Project: Willard Short Plat
Permit#: SP-22-00004
Date: 04/28/2022

To: Jeremiah Cromie, CDS Planner II
From: Dan Suggs, Environmental Health Specialist II
Date: 5/11/22
RE: SP-22-00004 Willard

SUBJECT: SP-22-00004 Willard Preliminary Short Plat Comments

HAYBROOK FARMS - PHASE 2
 PART OF GOV'T LOT 3, SECTION 30, T. 18 N., R. 19 E., W.M.
 AND OF THE E 1/2 OF SECTION 25, T. 18 N., R. 18 E., W.M.
 KITTITAS COUNTY, WASHINGTON

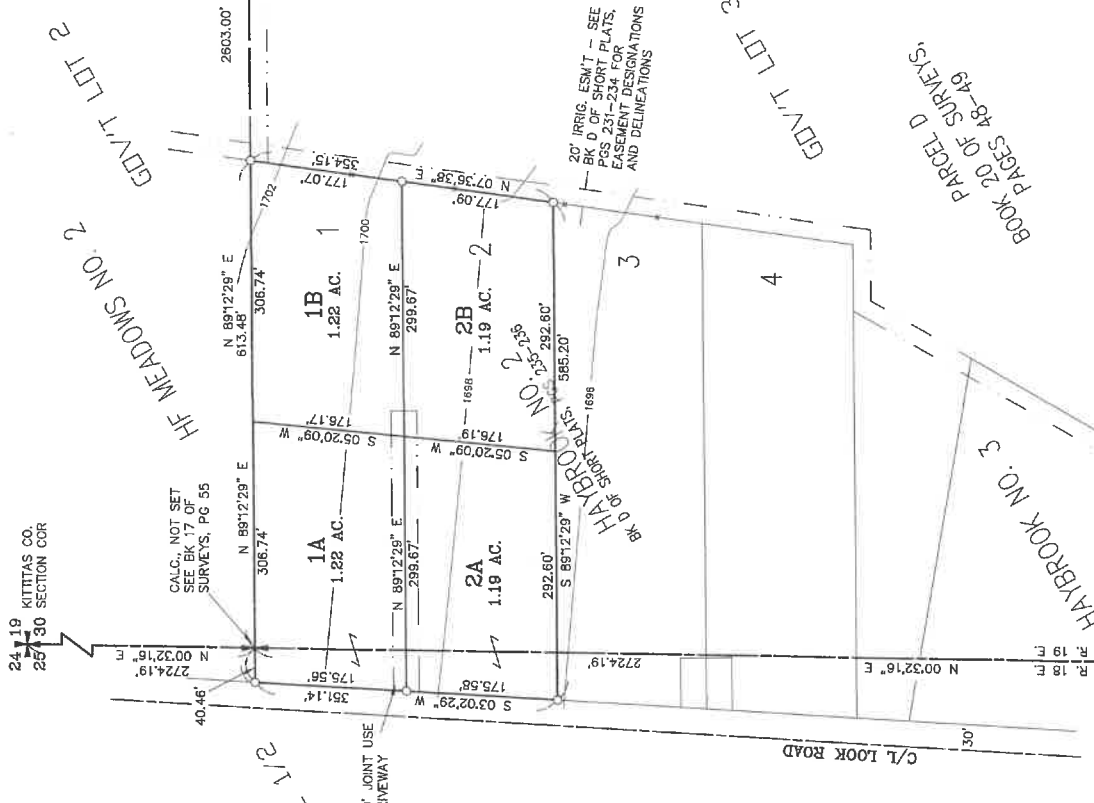
1. Lot Closure Sheet is missing (KCC 16.32.010(1)).
2. Purpose of Survey was not identified nor was the application number on the survey (KCC 16.10.020(1)).
3. Basis of Bearing was not identified on the map nor was it in the notes (WAC:332-130-050(1)(b)(iii)).
4. Roadway ownership and surfacing should be on the map.
5. If elevations or contours are to be shown, then the map must meet Topo Standards per WAC:332-130-145.
6. Irrigation easements should be shown on the map (KCC 16.12.020(11)).
7. Title report legal description does not match the legal description for original parcel description.
8. Joint-use driveway does not identify an easement. All access easements are to be shown (KCC 16.12.020(10)).
